INFRASTRUCTURE LIST

**DEVELOPMENT REVIEW BOARD (D.R.B.) REQUIRED INFRASTRUCTURE LIST
TRACTS 20A-1A THRU 20A-1I INCLUSIVE PARADISE NORTH WITHIN THE TOWN OF ALAMEDA GRANT PROJECTED SECTION 2, TOWNSHIP 11 NORTH, RANGE 2 EAST,
N.M.P.M. CITY OF ALBUQUERQUE BERNALILLO COUNTY, NEW MEXICO
PROPOSED NAME OF PLAT AND/OR SITE DEVELOPMENT PLAN**

**TRACT 20A-1 VACATION AMENDED PLAT & REPL OF PARADISE NORTH SITUATED WITHIN THE TOWN OF ALMENDA GRANT CONT 19.088 AC M/LOR 831,473 SQ FT M/L
EXISTING LEGAL DESCRIPTION PRIOR TO PLATTING ACTION**

UNSER BLVD

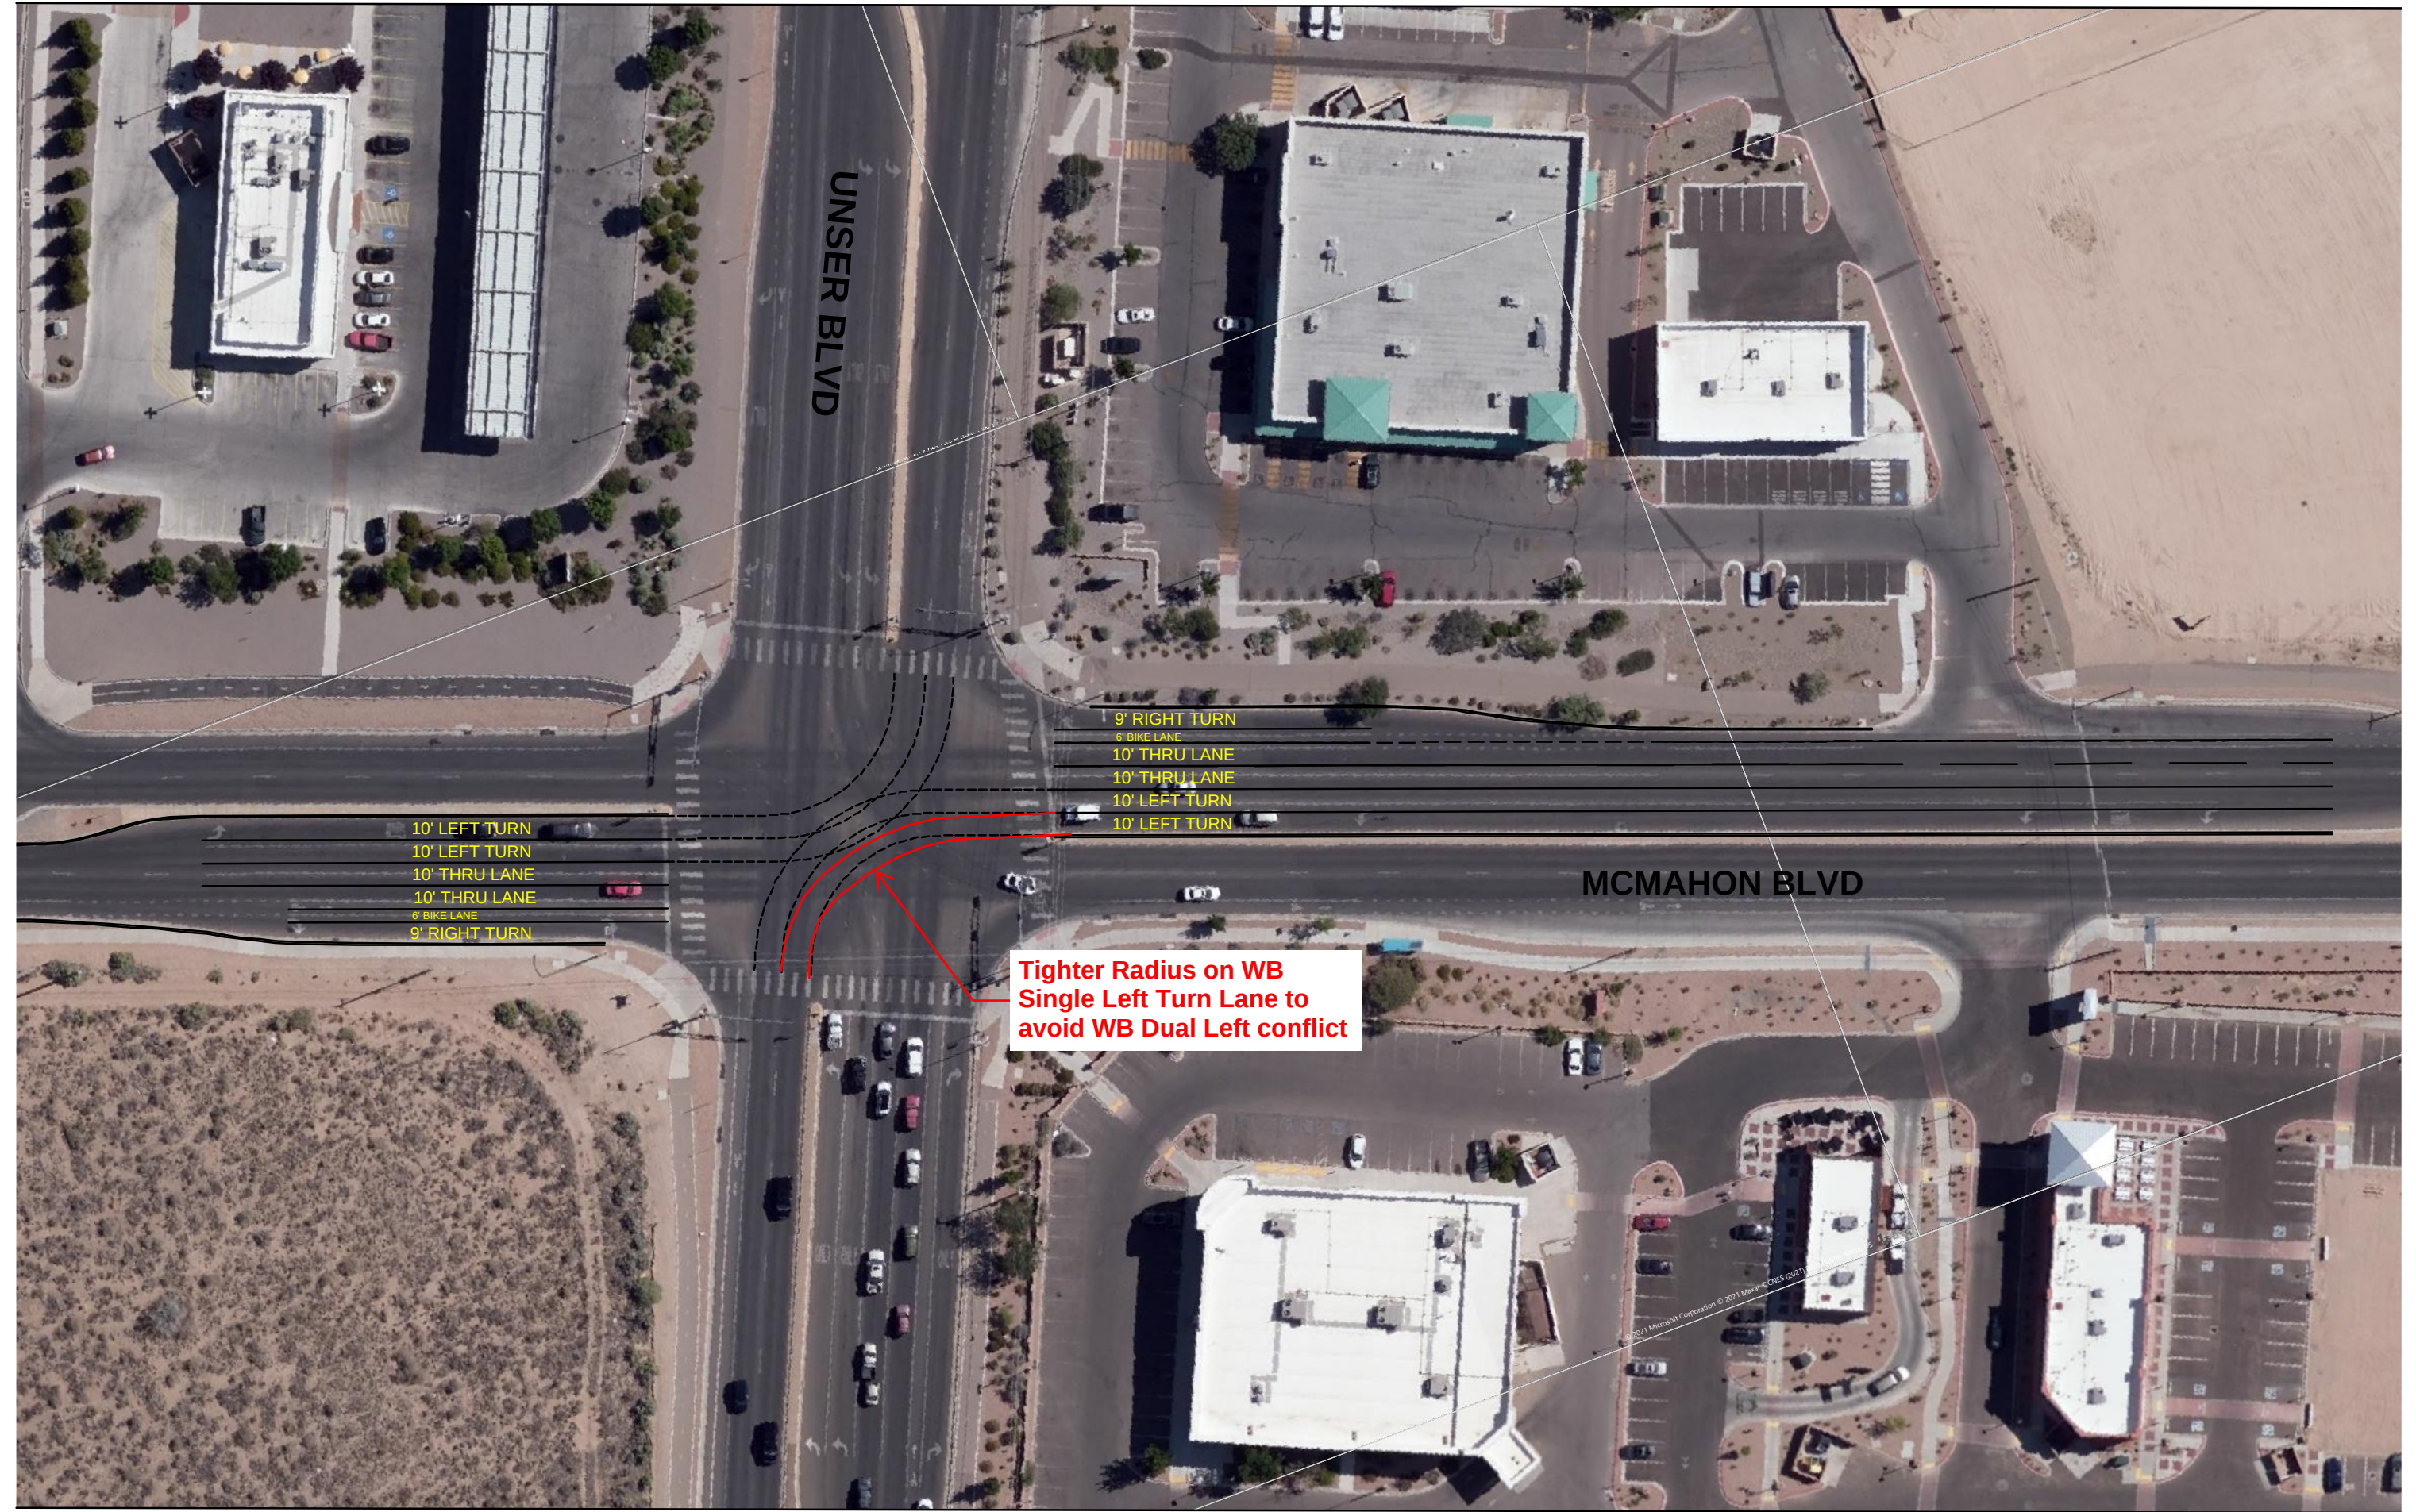
Is this including the transition length?

Provide more description, lanes and section width

Will other equipment be required,
